CITY OF ALBUQUERQUE
MUNICIPAL DEVELOPMENT DEPARTMENT
ENGINEERING DIVISION

CONFERENCE RECAP

SUBJECT: LOS TOMASES WAREHOUSE
LOT 3, BLOCK 16 OF THE HARRIS-MOORE ADDN

REF: LOS TOMASES WAREHOUSE (J14-D41) 6/22/84 1617 LOS TOMASES NW

GRADING & DRAINAGE PLAN  
LOS TOMASES WAREHOUSE

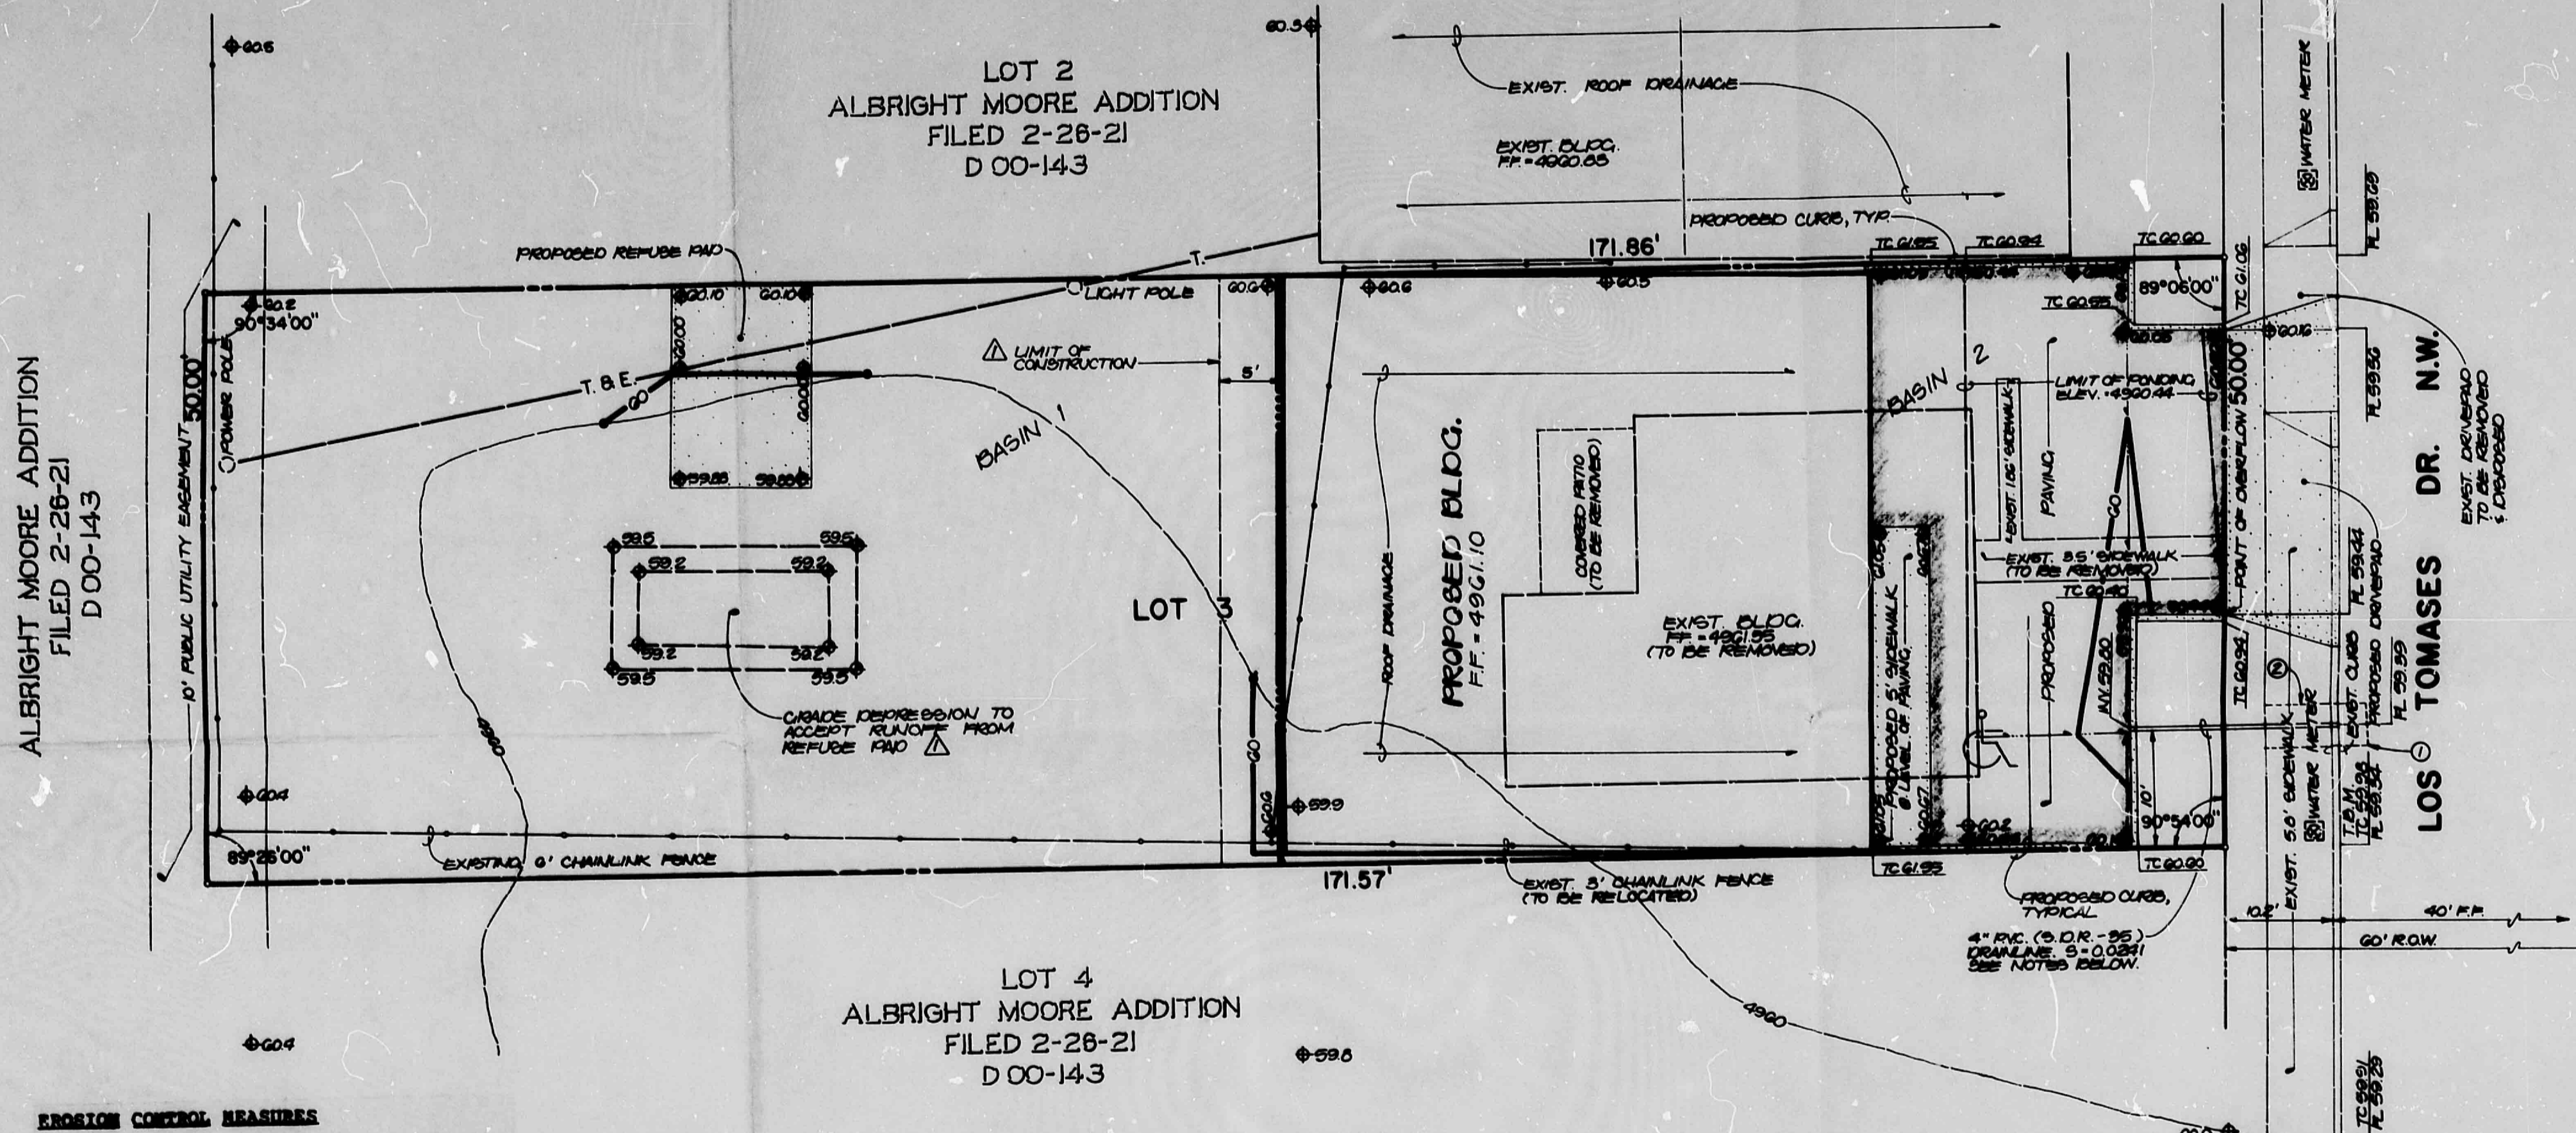
- FINDINGS: _____
1. DRAINAGE PLAN REQUIRED FOR BUILDING PERMIT SIGN-OFF
 2. NO GRADING PROPOSED IN THE REAR WITH THE EXCEPTION
OF THE REFUSE PAD, CONSEQUENTLY MINIMAL PONDING
REQUIRED TO INTERCEPT PAD RUNOFF
 3. ROUTE THE REMAINING DEVELOPED RUNOFF THRU A
LANDSCAPED AREA THAT OVERFLOWS TO THE R/W AND
THE DRIVEWAY

THIS HAS NO PROBLEMS ^{THAT} ~~AS~~ I CAN SEE.

Discussed the pond with Jeff
and recommended that it be
eliminated - Show limit of construction
and provide a small pond for the
refuse pad. Update to be forthcoming.
